TfNSW Reference: SYD21/00574/04

DPIE Reference: SSD-18204994

**EXHIBITION OF EIS - EXHIBITION OF EIS - SNACK BRANDS MANUFACTURING
FACILITY - 14 & 2 DISTRIBUTION DRIVE, ORCHARD HILLS**

Attachement A

ENTRY (FOR AV REAR LOADING)

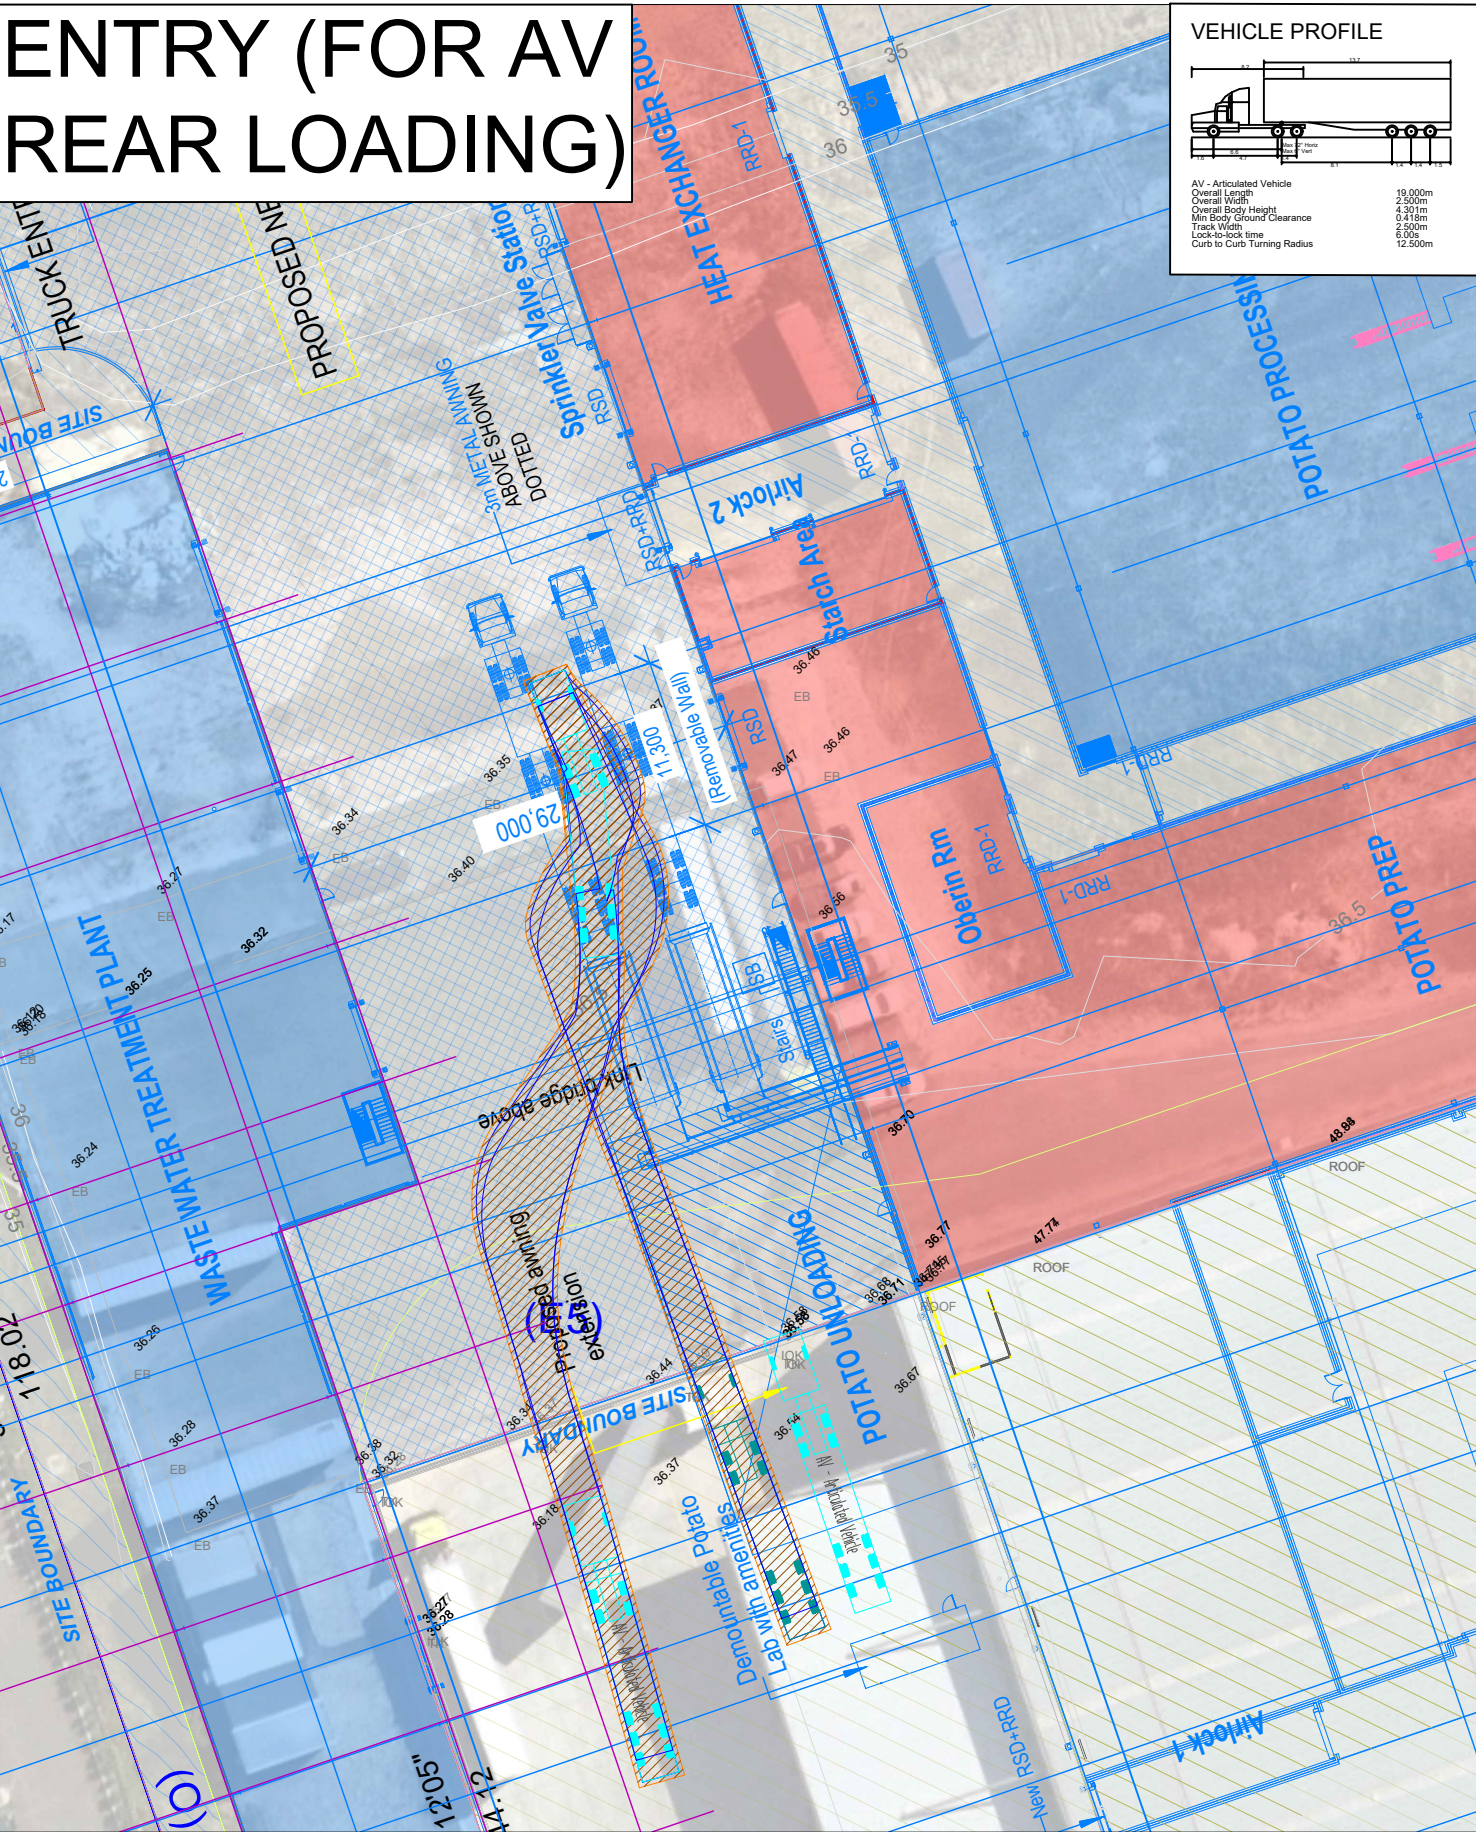
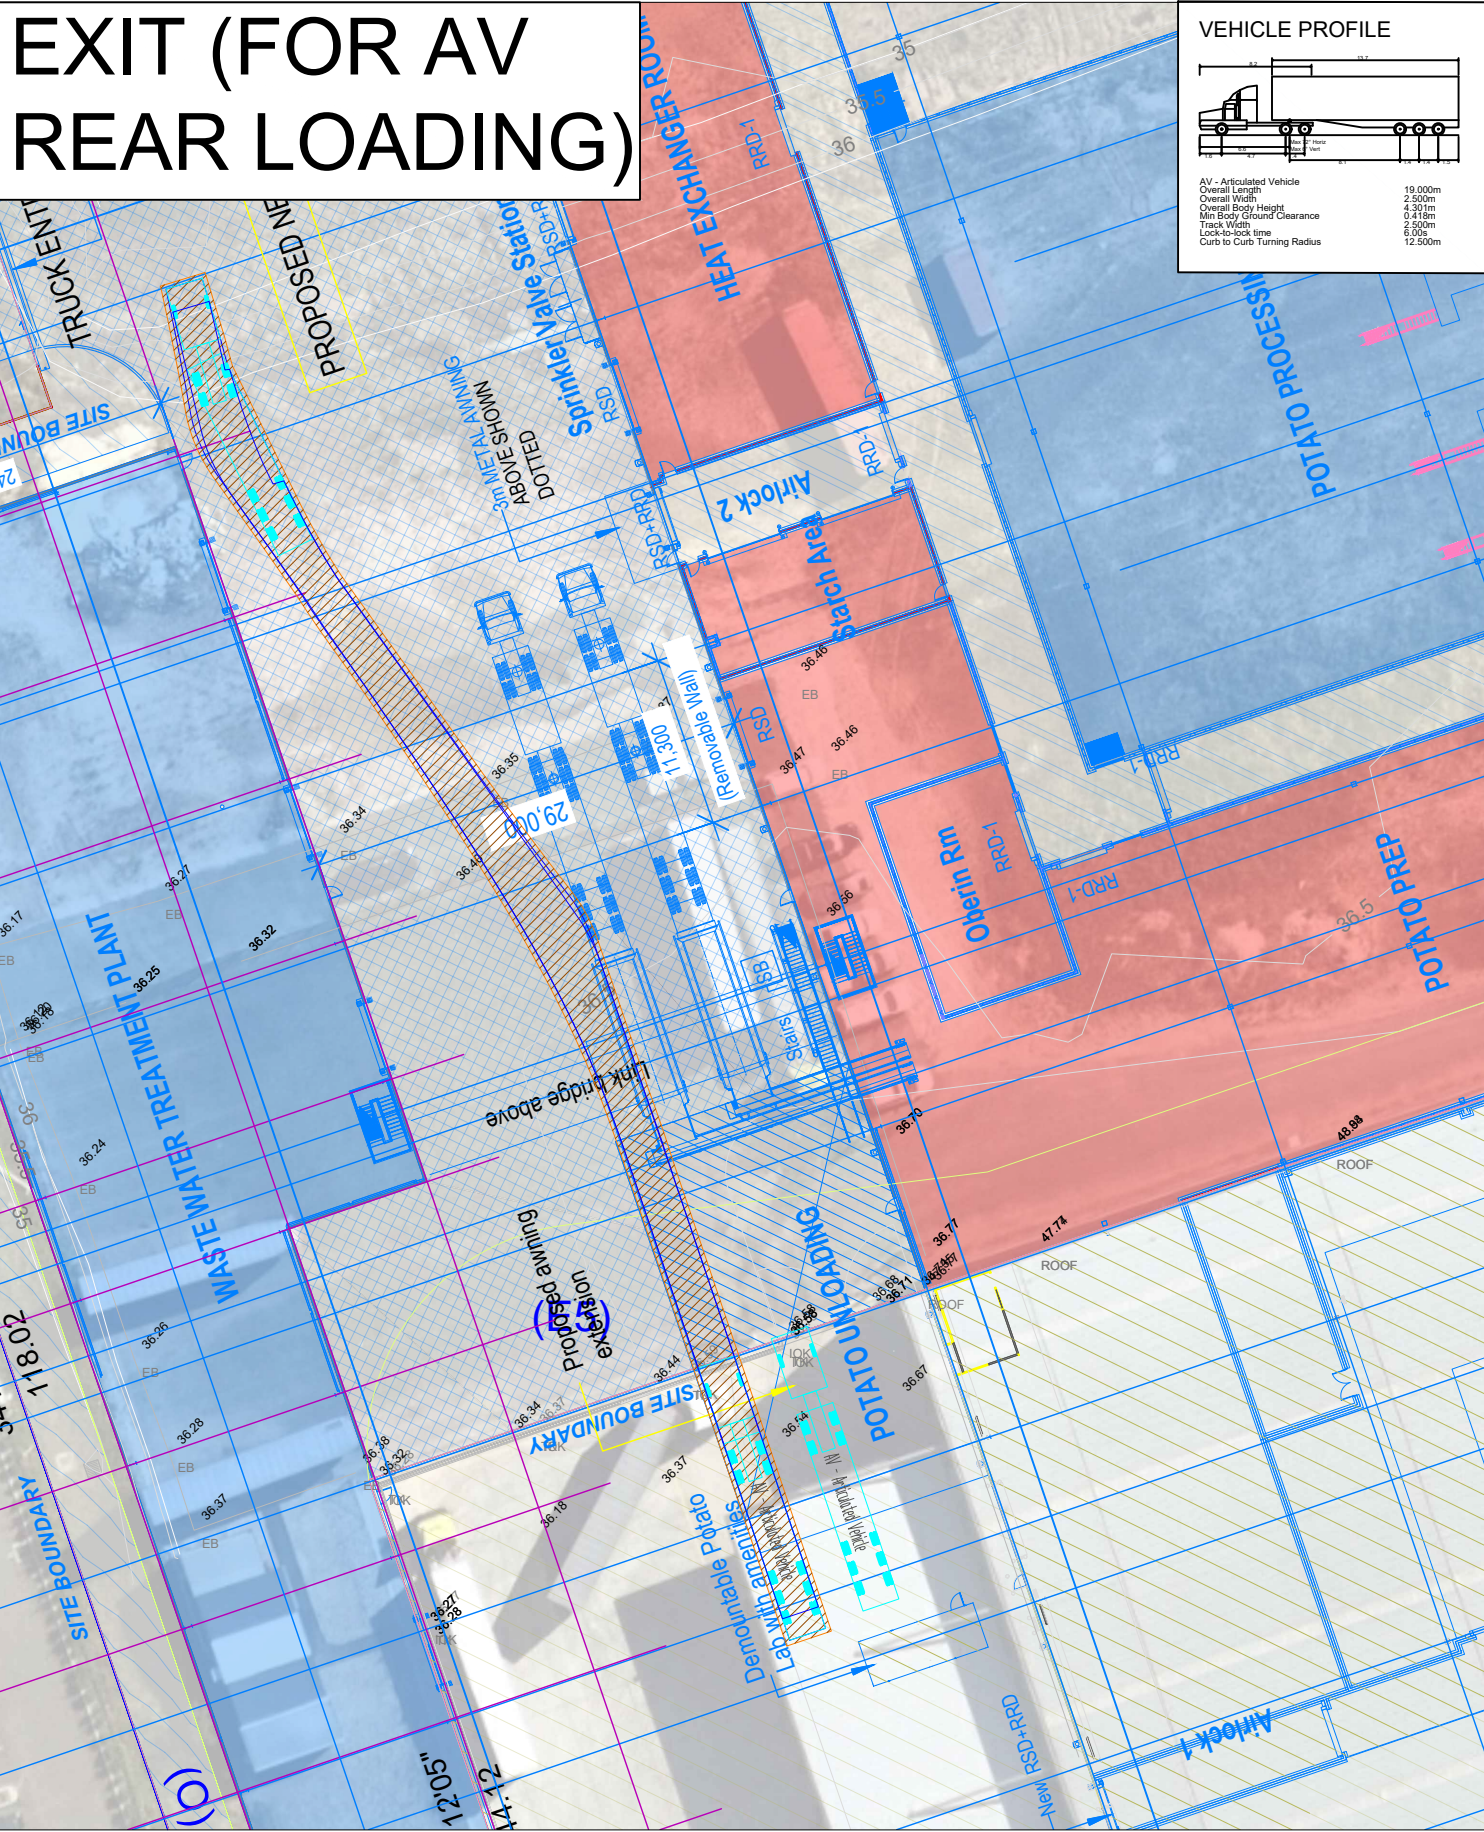
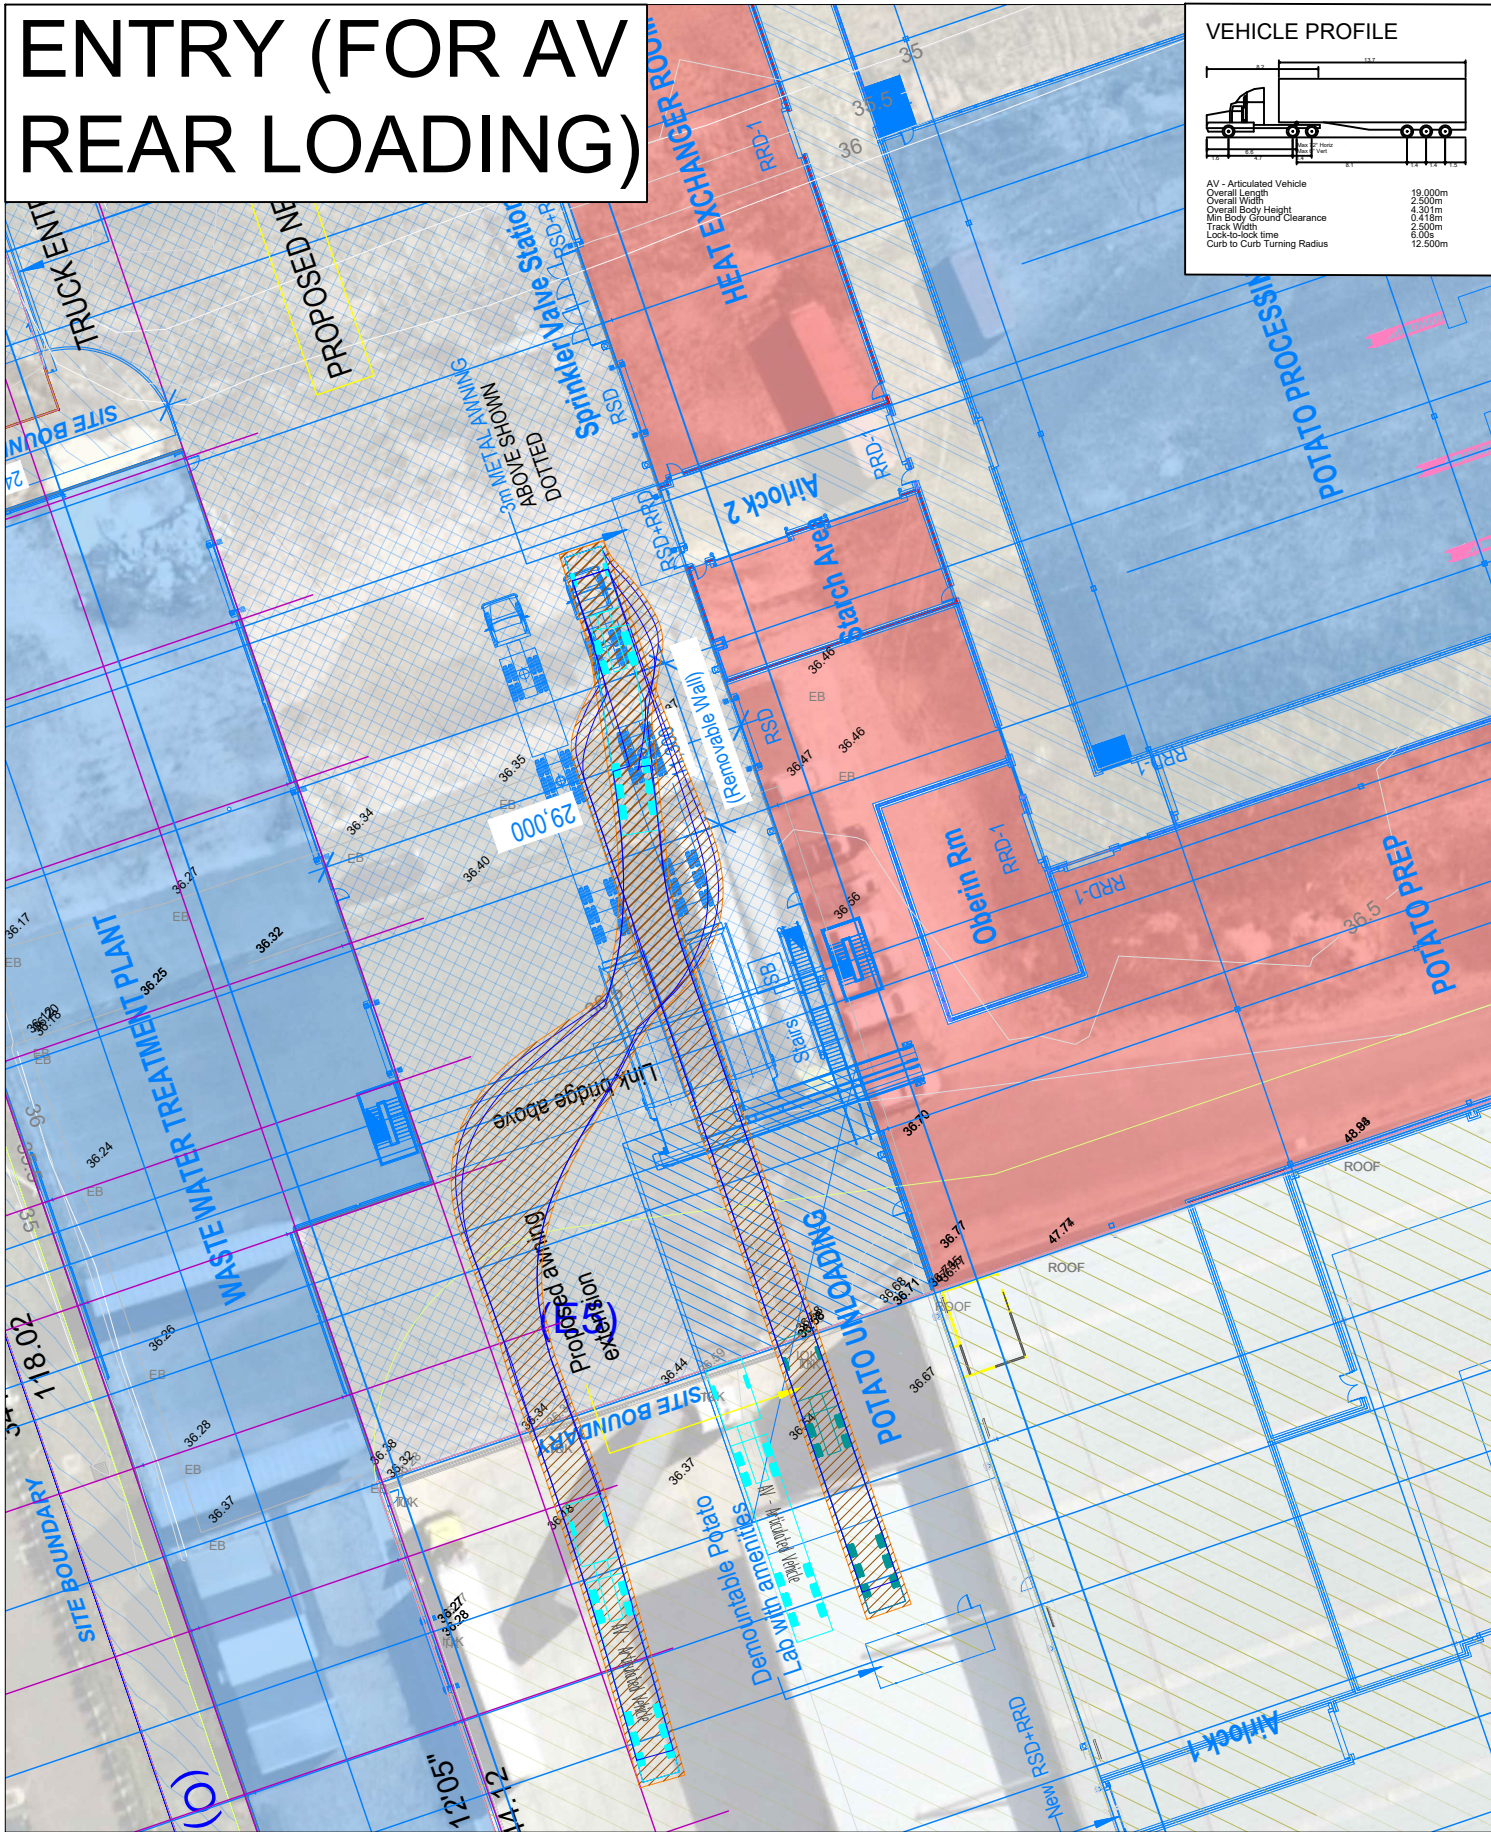
The TA has acknowledged two RSDs where B-doubles will be need to be reversed to unload from the rear. As the rear trailer is in the way, the front trailer (or A-trailer) of a B-double is typically unloaded by de-coupling the trailers, or jack-knifing the combination.

The TA needs to clarify whether a de-coupling area is required so that both the 'A' and 'B' trailers can be unloaded from the rear for the two RSDs which require B-double reverse movements.
